Our Ref: M/51/18/PL

14th May 2018

**Town & Country Planning Act 1990 (as amended)
Town and Country Planning (Development Management Procedure) (England) Order 2015
Application for Full Planning Permission**

Development Demolition of properties and construction of 1No new building comprising 1No 3bed and 1No 1bed properties.
Location 5A Tuscan Avenue and 6 Main Drive Middleton-On-Sea

SITE BLOCK PLAN 1:500

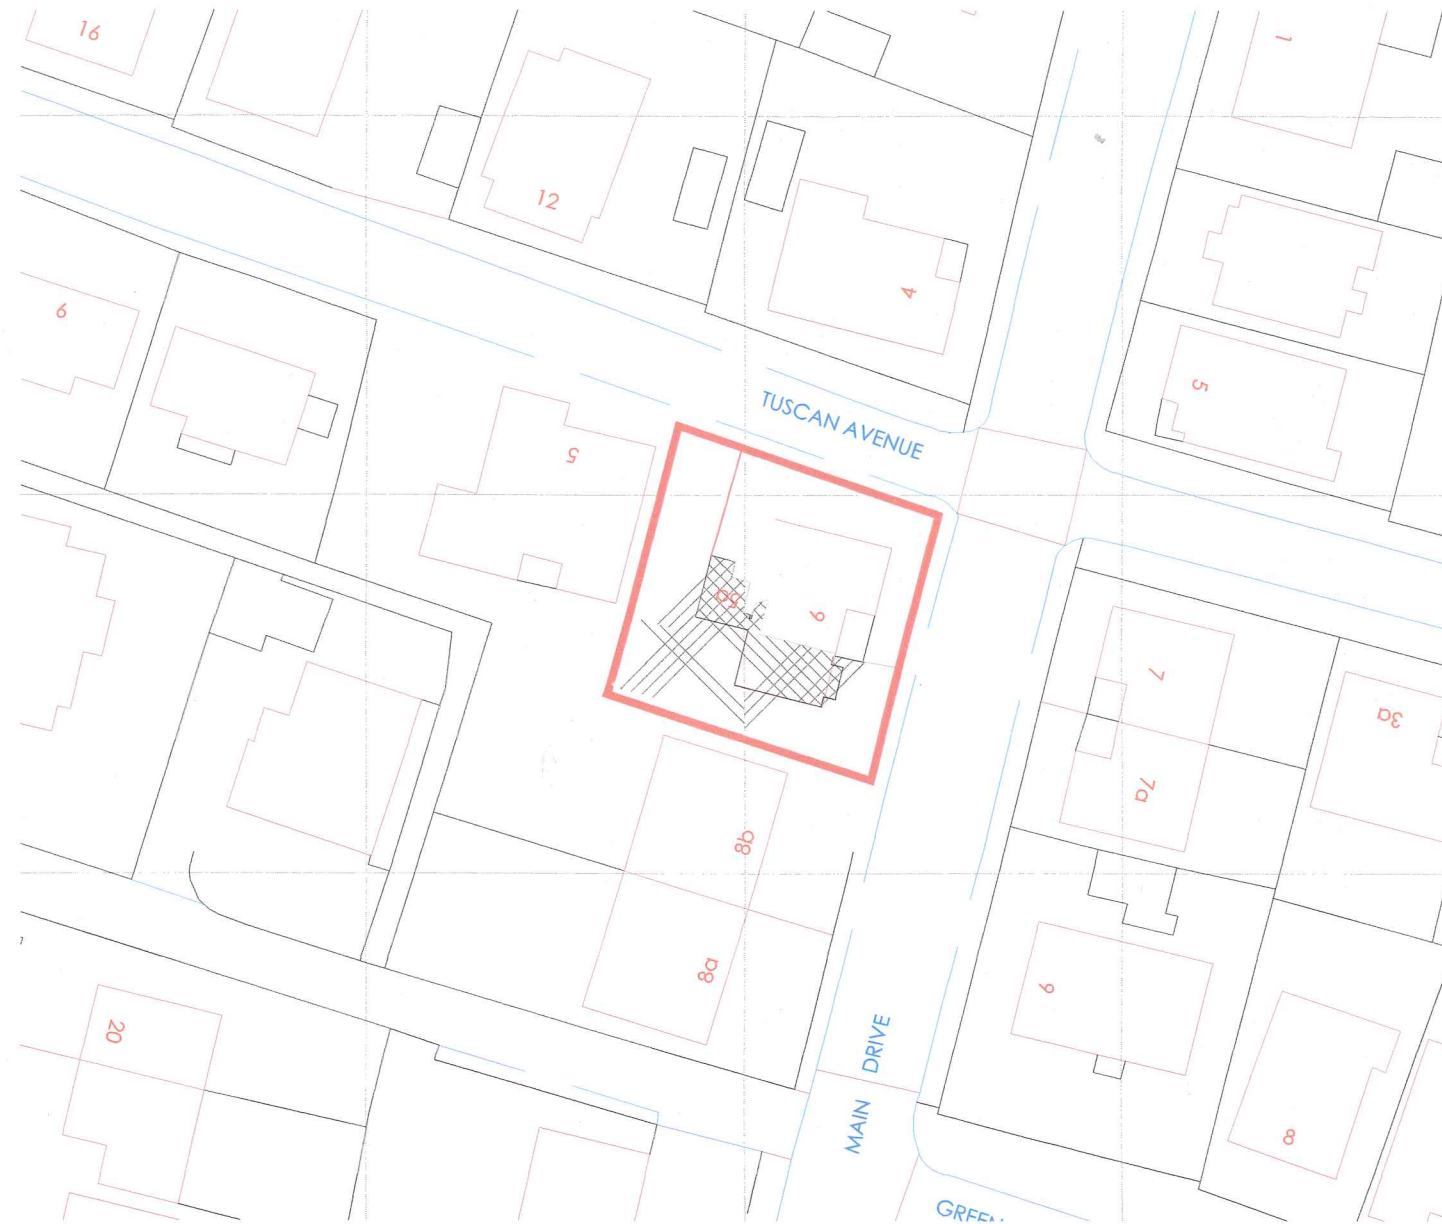
Block Plan - Amend

Please submit 1 electronic or 3 paper copies of an amended block/site plan at a scale of 1:500 or 1:200 to include dimensions shown from the new building to the boundary. Further details of what must be included on the plan can be found in the National Validation Requirements.

PROPOSED ELEVATIONS

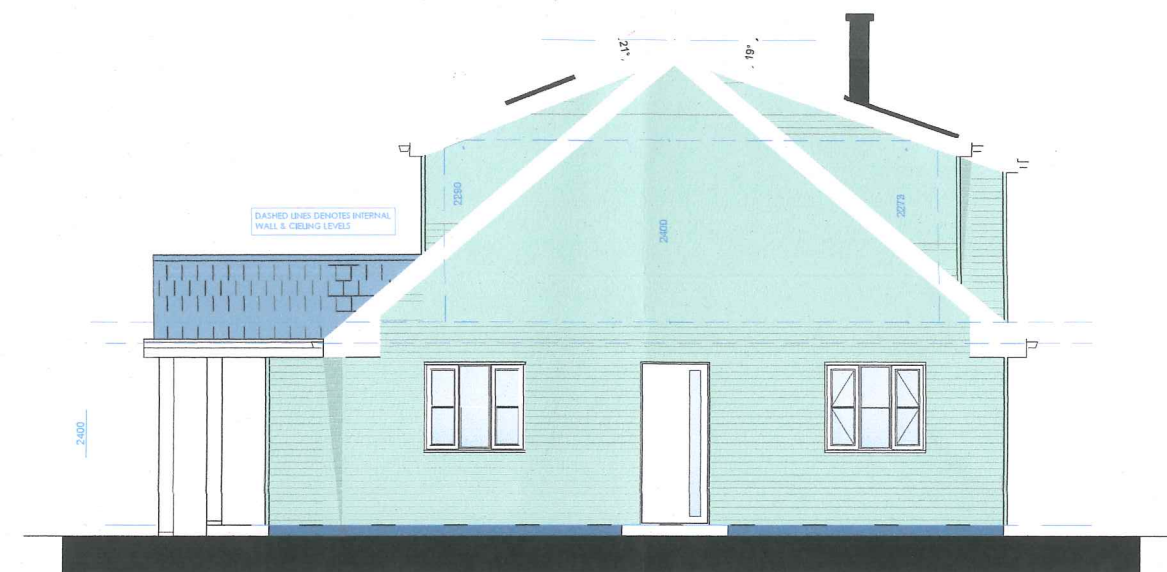
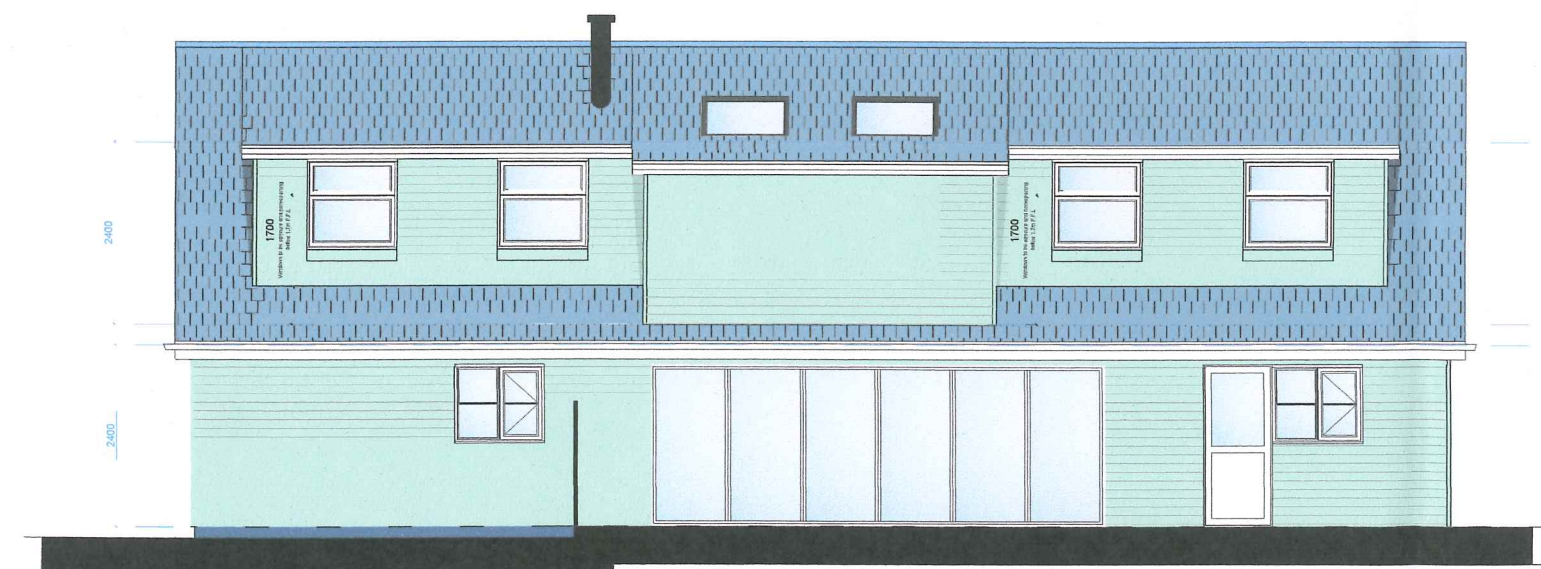
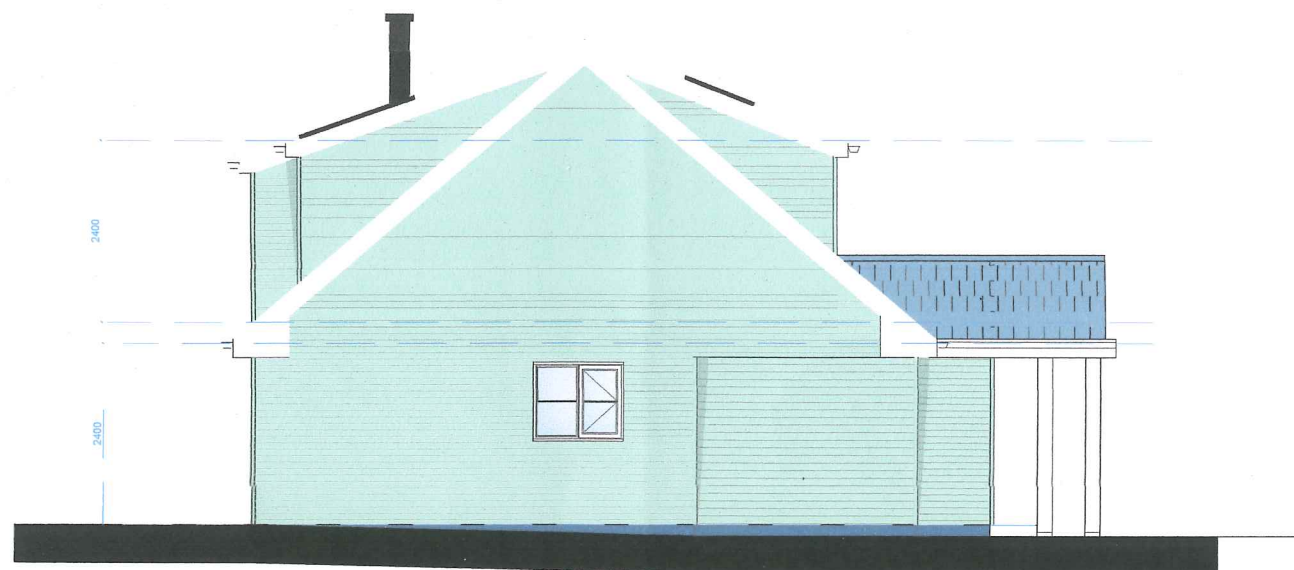
Elevations - Amend

The labels on the Elevations appear to be incorrectly labelled. Please amend the North, South, East and West labels accordingly.
